**Subject:** Rezoning Petition Review

**Rezoning Petition #:** 22-005

**Location of Property:** Approximately 2.97 acres located on the west side of West WT Harris Blvd, south of Mt. Holly-Huntersville Rd and north of I-485.

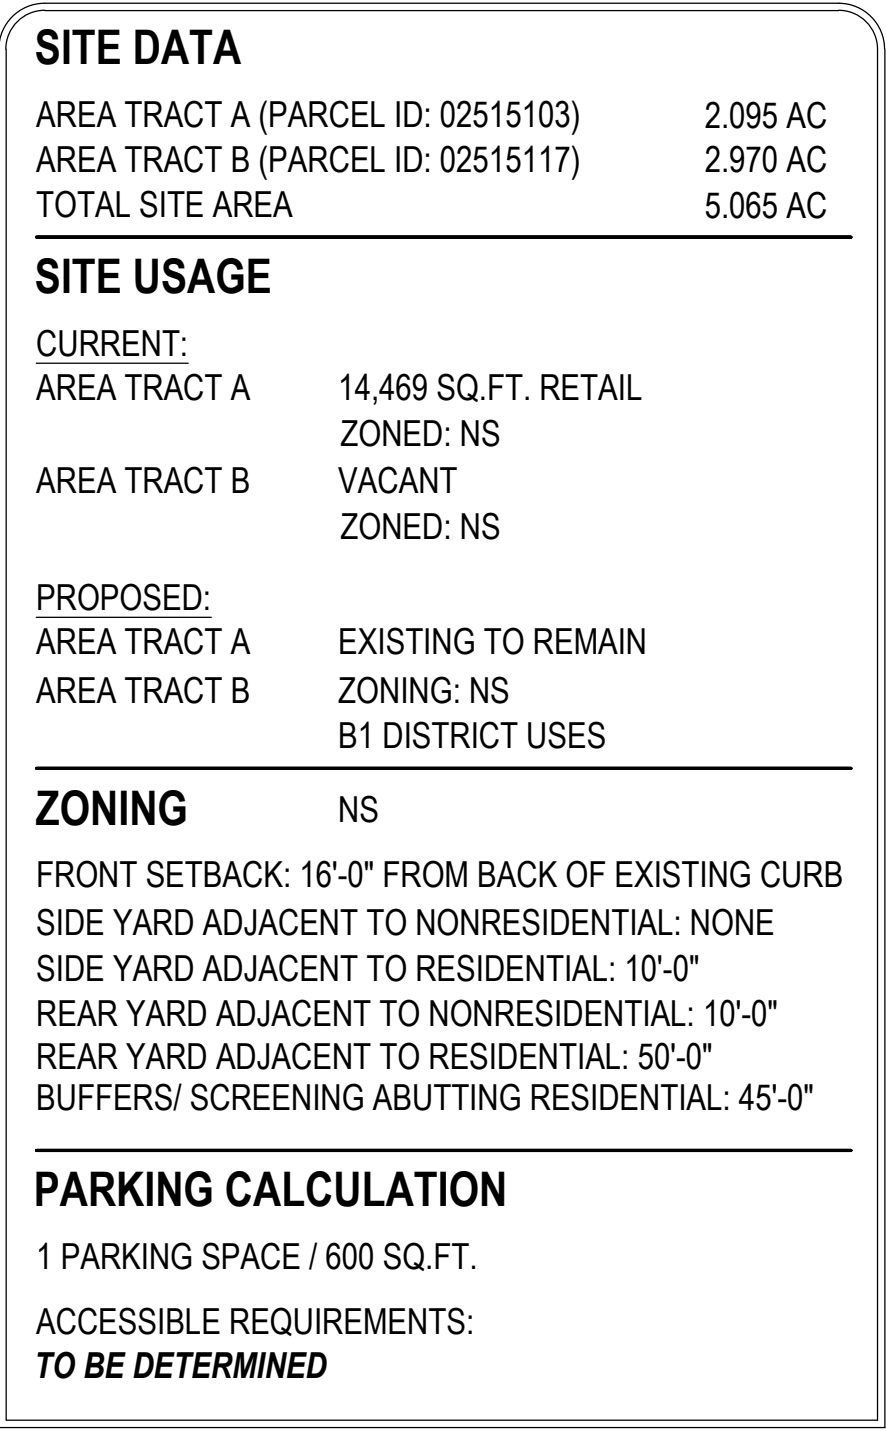
**Recommendations Concerning Storm Water:** Please include the following notes under "Environmental Features:"  
*The petitioner shall comply with the Charlotte City Council approved and adopted Post Construction Stormwater Ordinance. The location, size, and type of storm water management systems depicted on the Rezoning Plan are subject to review and approval as part of the full development plan submittal and are not implicitly approved with this rezoning. Adjustments may be necessary in order to accommodate actual storm water treatment requirements and natural site discharge points.*
